From: Niland, Mark
Sent: 04 August 2025 12:33
To: _planningadvice
Subject: FW: Land at Horseshoe Road

H16-0515-25 - Land at Horseshoe Road

From: Samantha Legg <Samantha.Legg@lincolnshire.gov.uk>
Sent: 30 July 2025 15:38
To: Niland, Mark <Mark.Niland@sholland.gov.uk>
Subject: RE: Land at Horseshoe Road

Horseshoe Road, Spalding: Overall Masterplan. LS01 (1:500 @A1)

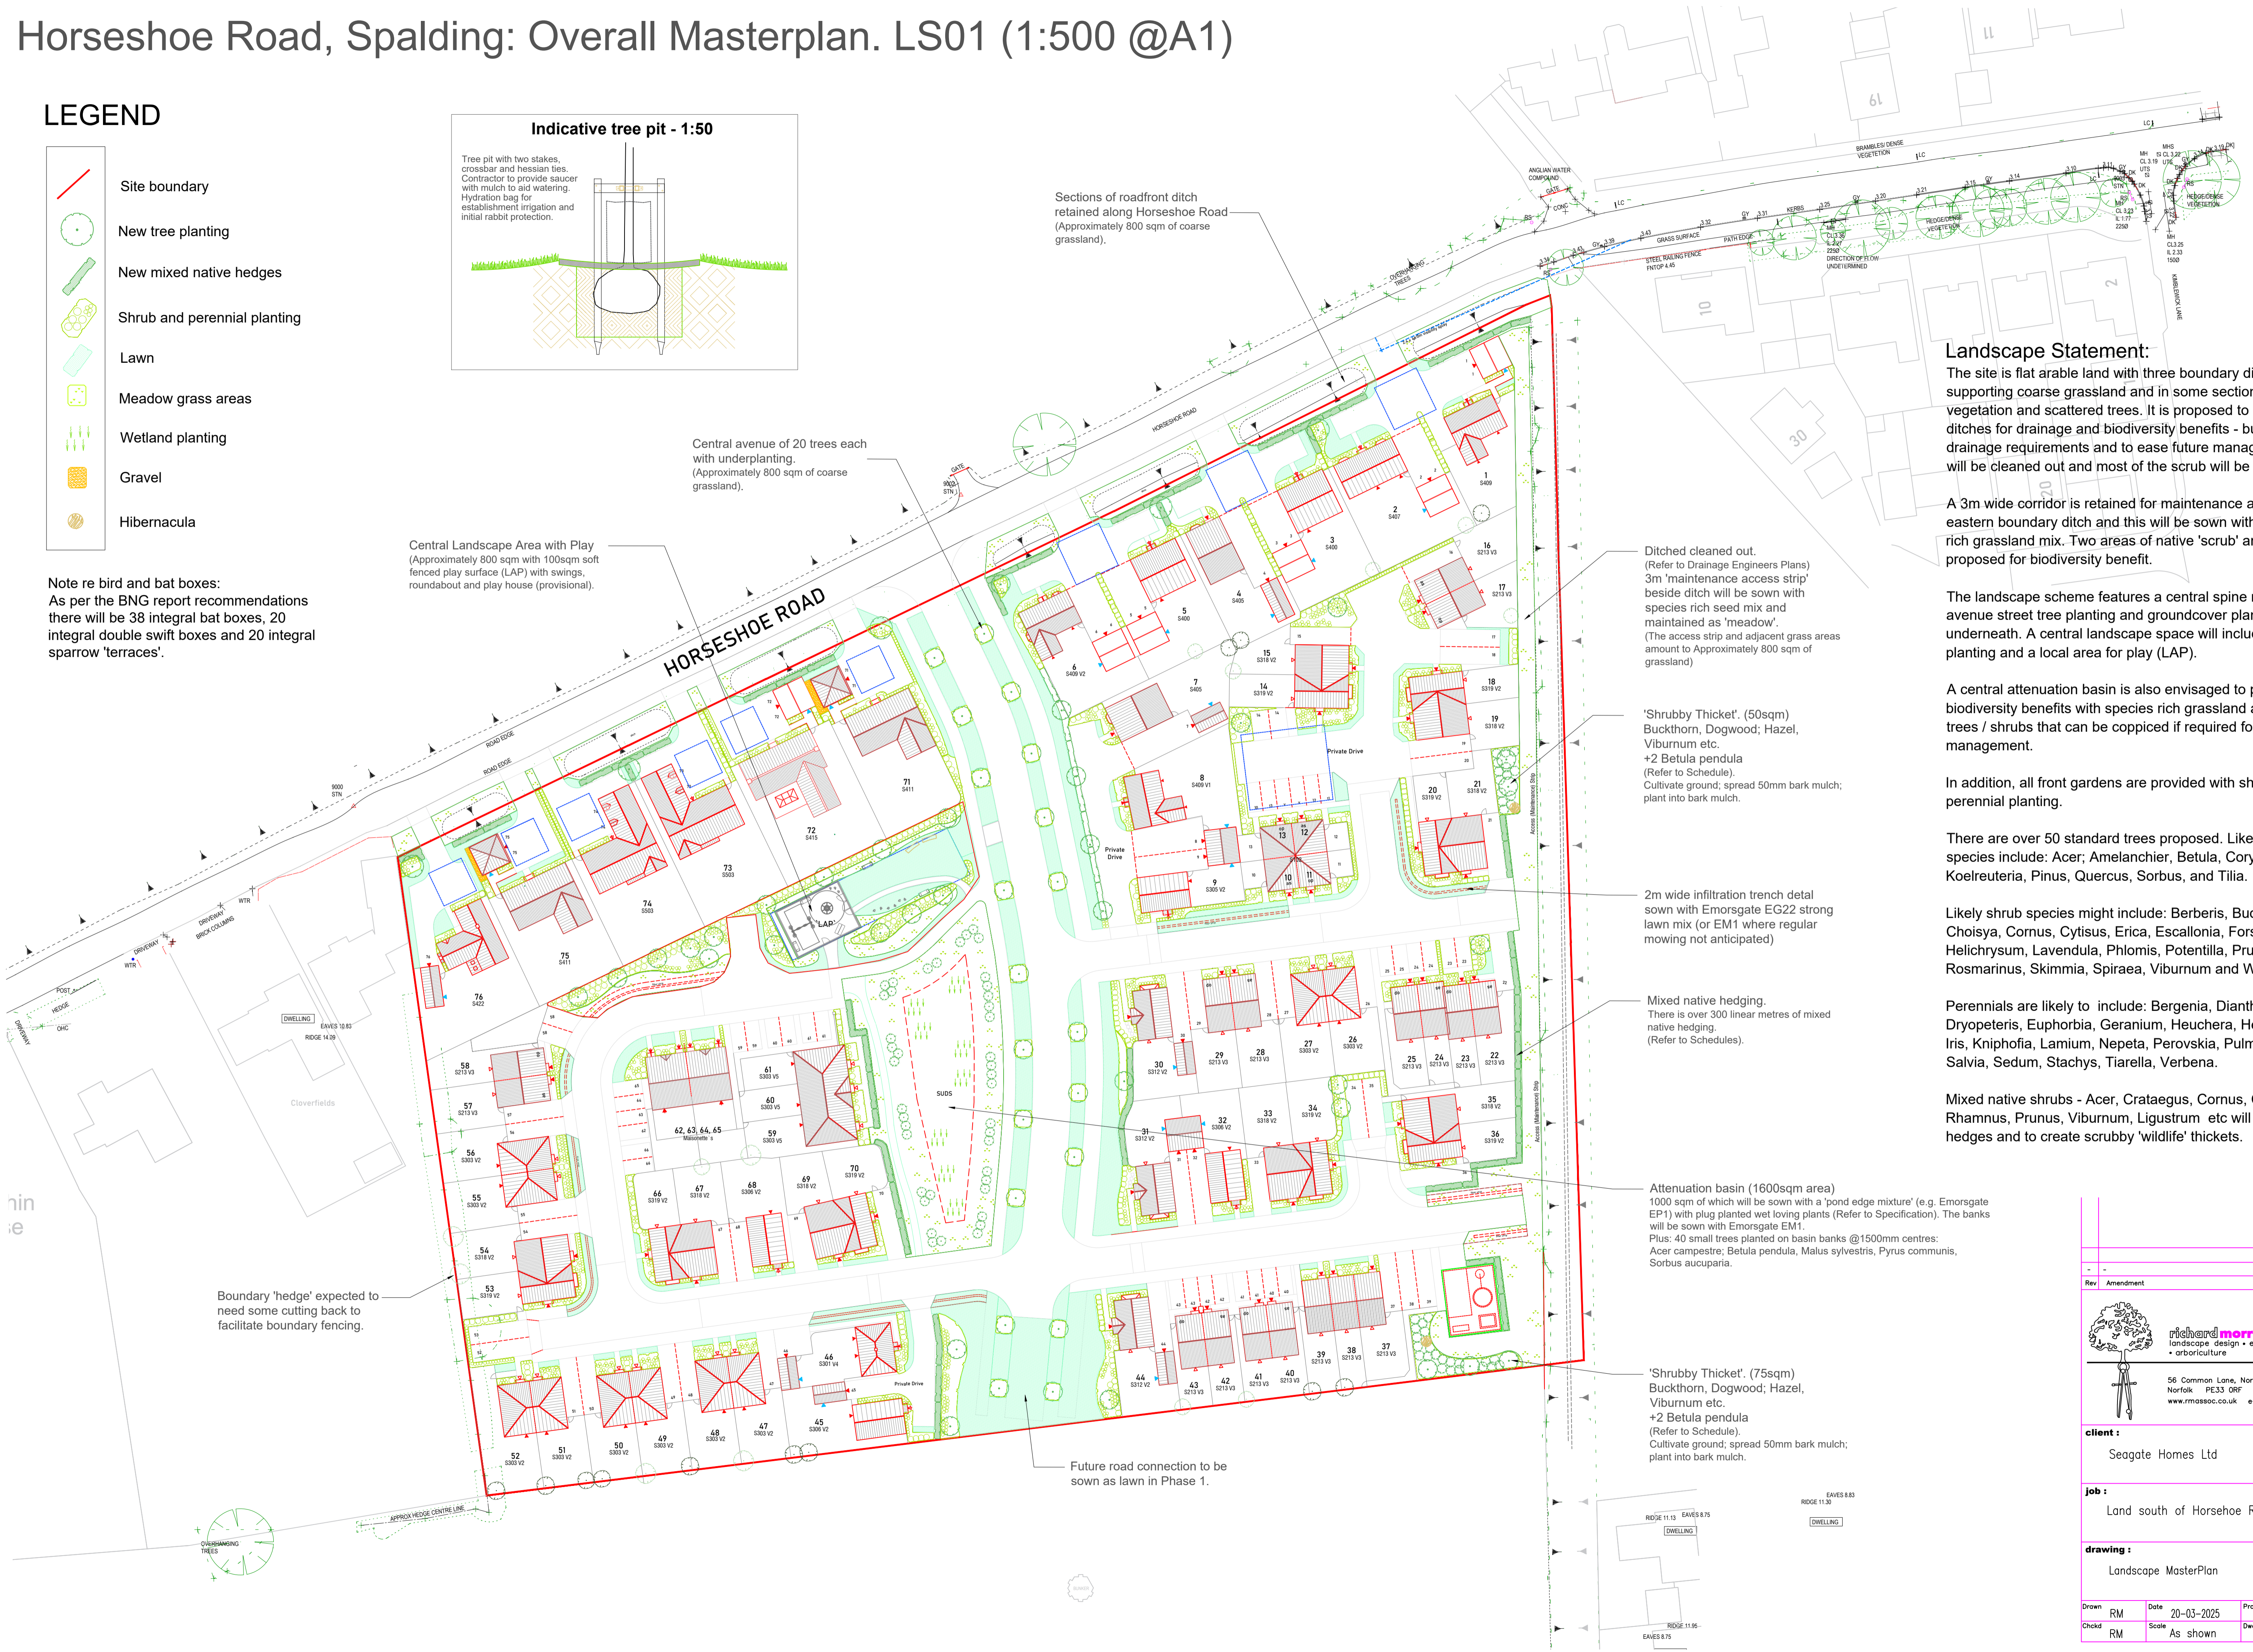
2. The large footway expanse at the junction is unnecessary – it should be reduced and street trees incorporated.
 - The applicant wants to know if this is a highway safety issue. **We would not want to adopt such a large expanse of tarmac when it isn't necessary – not a highway safety issue.**
